D2022-1 Part 1
Parcel 51478
AD22/45681

Apsley Battery Energy Storage System SSD-35160796

Property: Lot 3 DP 1012686 & Lot 107 DP 756920,
9010 Mitchell Highway APSLEY
Proposed development: Apsley Battery Energy Storage System

Figure 2 | Indicative Project Layout

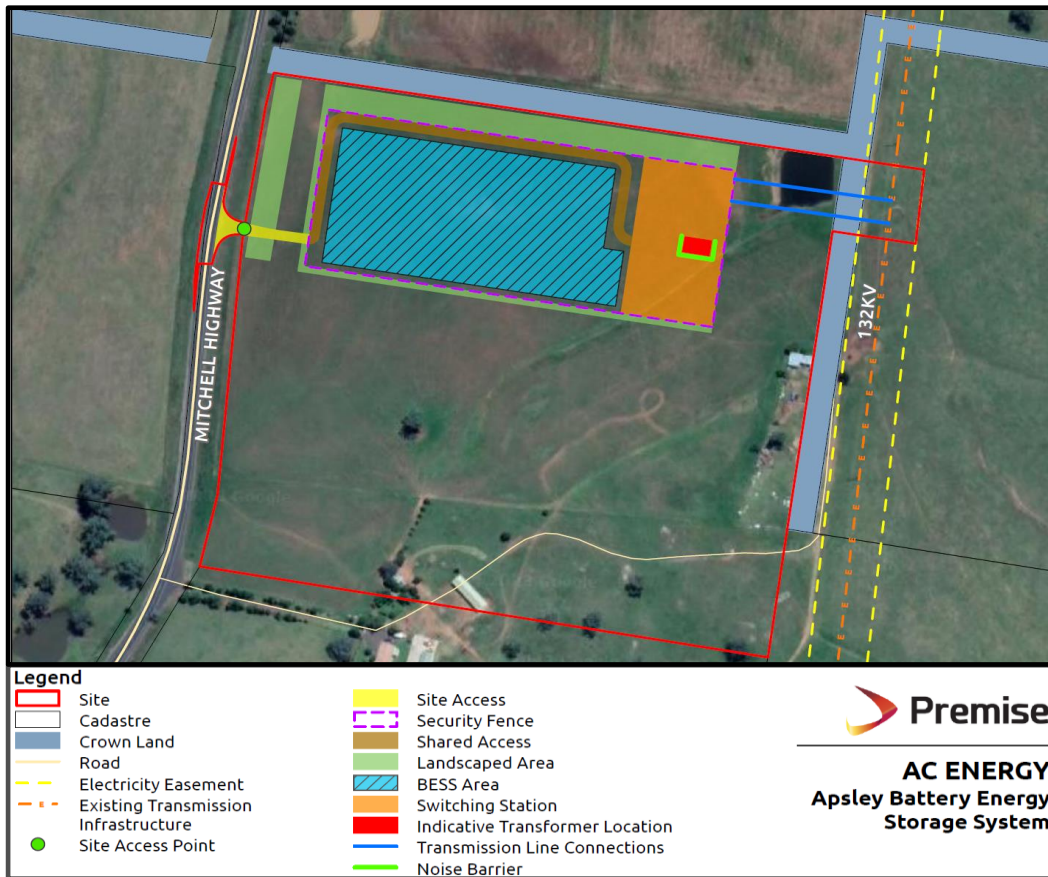
The proposed Battery Energy Storage System is proposed to occupy some 6 ha, comprising of 40 foot battery containers (numbers?), 40 foot inverter & MPVS containers (numbers?), switching station, car park (400m²), storage enclosures, control room, construction site offices, amenities, fencing, lighting, etc.

Council in its previous correspondence dated 17 February 2022 requested that the EIS provide some basic plans (indicative) for the works proposed, enabling Construction Certificates (as required) to be issued against approved plans. The submitted EIS contains Figure 3 – Site analysis and proposed development (p.10), which shows a hatched area on Lot 2.

This does not adequately address Council's concerns, nor does it provide a representation of the proposal.

Council notes that the highway in this location is the responsibility of Transport for NSW (TfNSW), and it is understood that TfNSW will issue a s138 approval to gain vehicular access to the highway. Noting the comments regarding the plans above, the proposed driveway is only shown indicatively on Figure 3.
